RE: Greenspot Wetherill Park – SSD 7401 – Response to comments

I make reference to your email comments received on Thursday 19 October 2017 for the abovementioned project proposed by Bettergrow. The following information seeks to address the comments provided by the Department and resolve any outstanding information requests.

Figure 2 from the Traffic Impact Assessment prepared by Thompson Stanbury (below) shows the weekday peak hour traffic volumes between 7:00am-8:00am and 4:00pm-5:00pm.

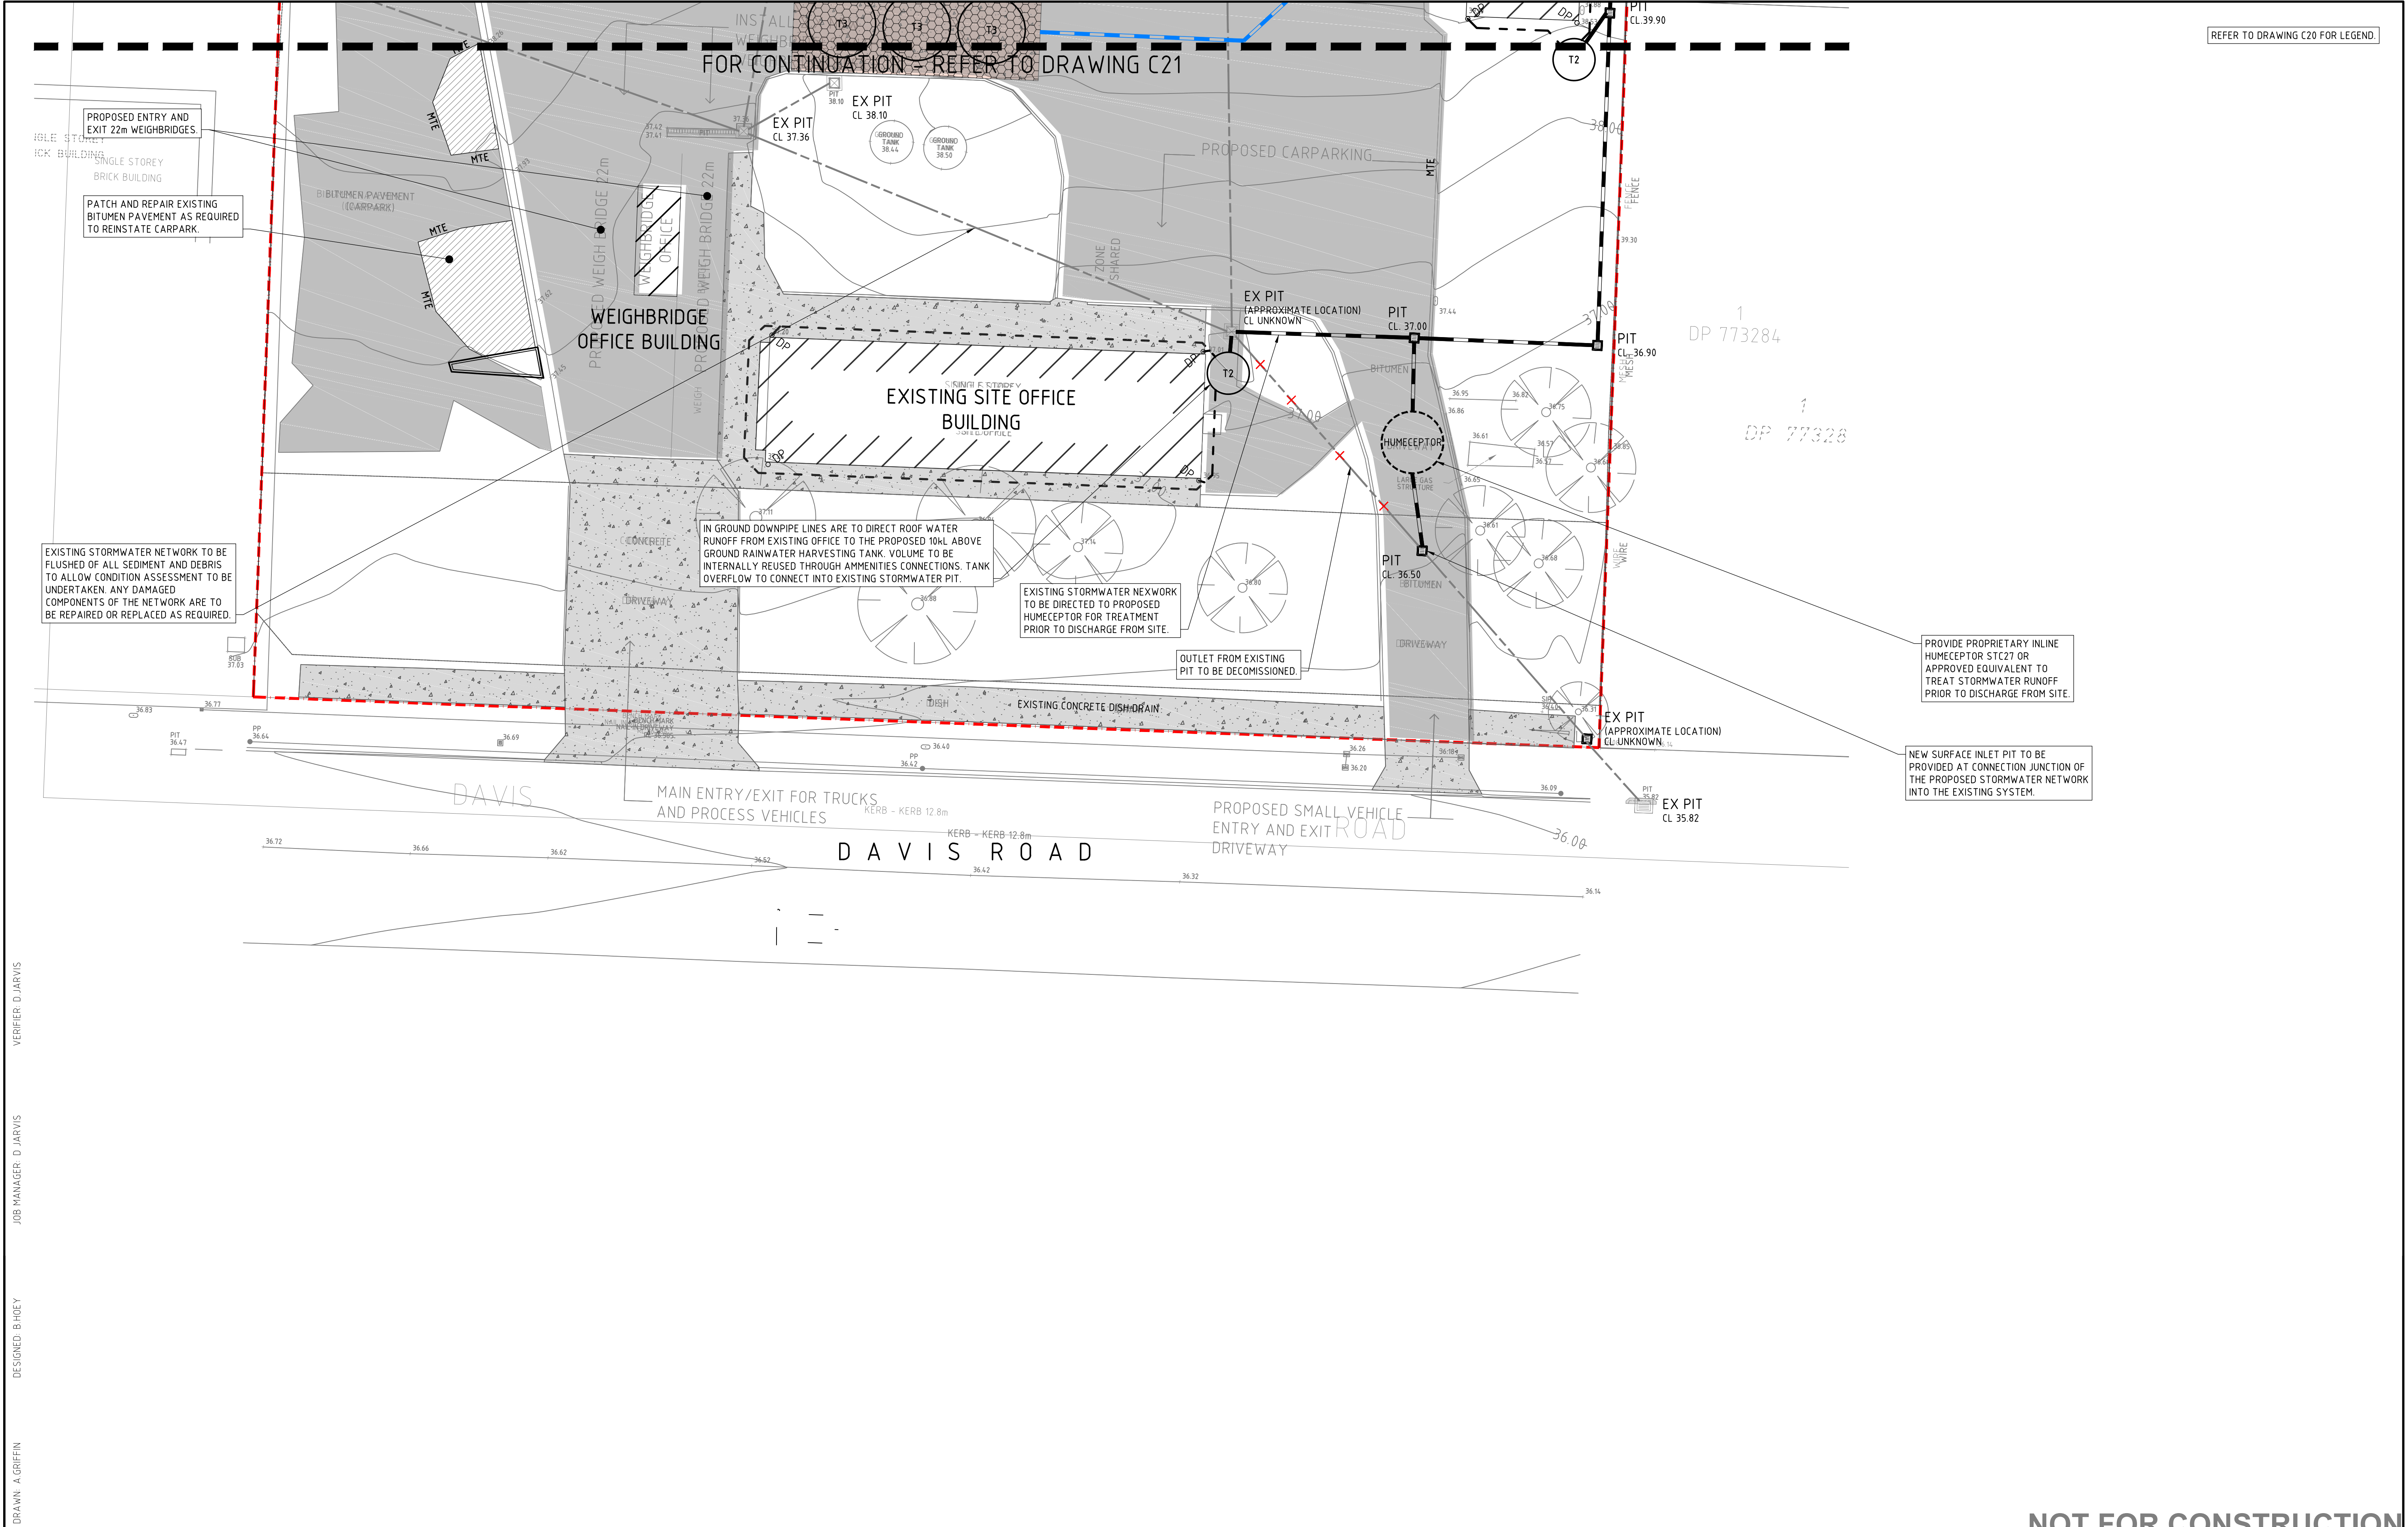
8. Please provide further justification on why the landscape supplies facility is not proposed to be roofed and how surface water run-off from the landscape supplies area will be managed (i.e. whether it is proposed to divert the run-off to the wastewater management system, if so, it needs to be demonstrated that the wastewater management system is capable of processing the additional surface water run-off).

9. Please detail how external fire water would be managed.

As such, Bettergrow proposes to treat the yard in the bulk landscape area with a 2 coat tar seal and still send the water to stormwater as per the current design prepared by Northrop for the EIS. The sealing of this area will reduce the potential for sediment to be generated and entrained to the site stormwater system. The proposed stormwater system to treat water from this area includes the following key components:

- Surface water runoff from the bulk landscaping area is proposed to be directed to a sediment trap with a minimum storage volume of 41kL. The system has been designed in accordance with NSW Managing Urban Stormwater: Soil's and Construction 'Blue Book' guidelines to capture sediment laden rainfall from across the area. Given the sealed nature of the surface with minimal fines, the trap has been sized as a type C basin to collect coarse sediment, assuming a peak runoff coefficient of 0.8; and

- The piped stormwater network is also to be directed to a proprietary STC-27 Humeceptor system. The Humeceptor system is an underground, precast concrete stormwater treatment solution that utilises hydrodynamic and gravitational separation to efficiently remove total suspended solids (≥ 10 microns) and entrained hydrocarbons. The proposed system has been designed to provide a storage volume of 27kL, including an oil storage volume of approximately 4000L in case of onsite spillages.

Should a fire occur at the site, all fire water generated external to the processing buildings on the upper level will be captured and managed through the ability to isolate the site stormwater system from the Council stormwater system. The site stormwater system includes a sediment trap in the bulk landscape area with a capacity of 41kL. From the sediment trap the system then connects with a secondary treatment device (Humeceptor STC-27) that will have a capacity of 27kL. The entire system will have the ability to be shut off from the external street system by way of a gate valve on the outlet side of the Humeceptor. The two treatment devices will act as containment for fire water in the event of a fire.

The figure below is extracted from the Surface Water Assessment prepared by Northrop. Shown on the figure is the location a gate valve which will be installed to isolate the site surface water system from the Council stormwater system.
